28 June 2018

Narrabri Gas Project – Response to Submissions Expert Review

This letter is to follow-up my previous advice regarding the Narrabri Gas Project, which was requested on behalf of the North West Alliance. I have now read the “Narrabri Gas Project – Response to Submissions” provided by Santos and can make the following brief observations.

Figure 7-4 Overview of the water treatment process

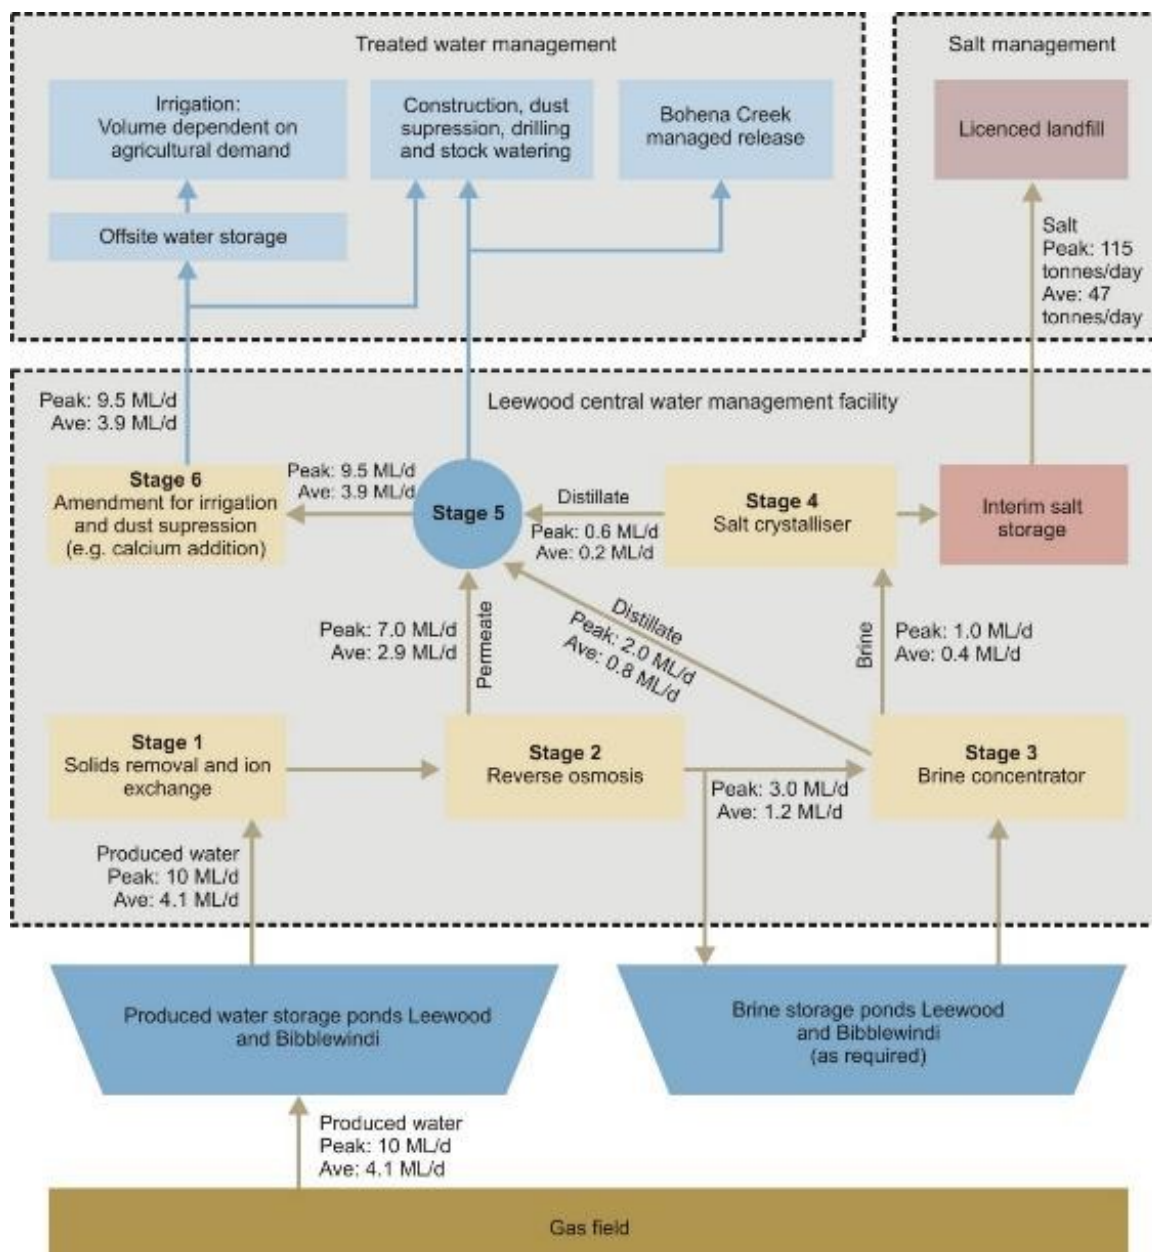
In section 7.8.1 “Salt Volumes”, it is stated that “produced water was heated in the laboratory to 180 degrees Celsius to simulate the thermal process used during water treatment. During heating, some salt in the produced water decompose, while the remainder become a solid salt product. After taking into account decomposition resulting from heating, the typical mass of salt produced is 11,700 milligrams per litre of water fed to the water treatment process”.

The fact that the initial salt concentration (in mg/L) does not seem to be provided, makes it difficult to understand the mass balance for the above paragraph. However, it is clearly implied that some chemical change is understood to take place. In my opinion, this needs to be supported with some clear and balanced chemical reactions. In addition, the EIS needs to answer the following questions:

- *What salts are being changed and into what products?*
- *What is the mass loss of salt relative to the initial mass?*
- *How is that loss accounted for?*
- *Does this change produce gaseous products?*

However, this response is really just a repeat of what was already stated in the EIS. The concerns I express above do not appear to have been addressed in the Response to Submission. It remains unclear how salt from produced water at a mean of 14,700 mg/L becomes only 11,700 mg per litre of (unconcentrated) produced water. No answers are apparent to the questions which were asked. Consequently, I find it difficult to accept, without further explanation, that the final mass of salt following brine treatment will be significantly less than the total mass of salt extracted from the coal seam. If mass loss is assumed to occur as a consequence of gaseous emissions, these emissions should be clearly stated and quantified.

To determine the volume of solid salt product the project would generate, laboratory work was undertaken to imitate the Leewood water treatment process (explained in Section 6.2.1 of Chapter 6 of the EIS), using conditions likely to achieve a similar level of decomposition. Specifically, the produced water was heated in the laboratory to 180 degrees Celsius to simulate the thermal process used during water treatment. During heating, some salt in the produced water decompose, while the remainder become a solid salt product. After taking into account decomposition resulting from heating, the typical mass of salt produced is 11,700 milligrams per litre of water fed to the water treatment process. This factor has been used to determine the estimated salt production rate, and subsequently, its volume and weight.
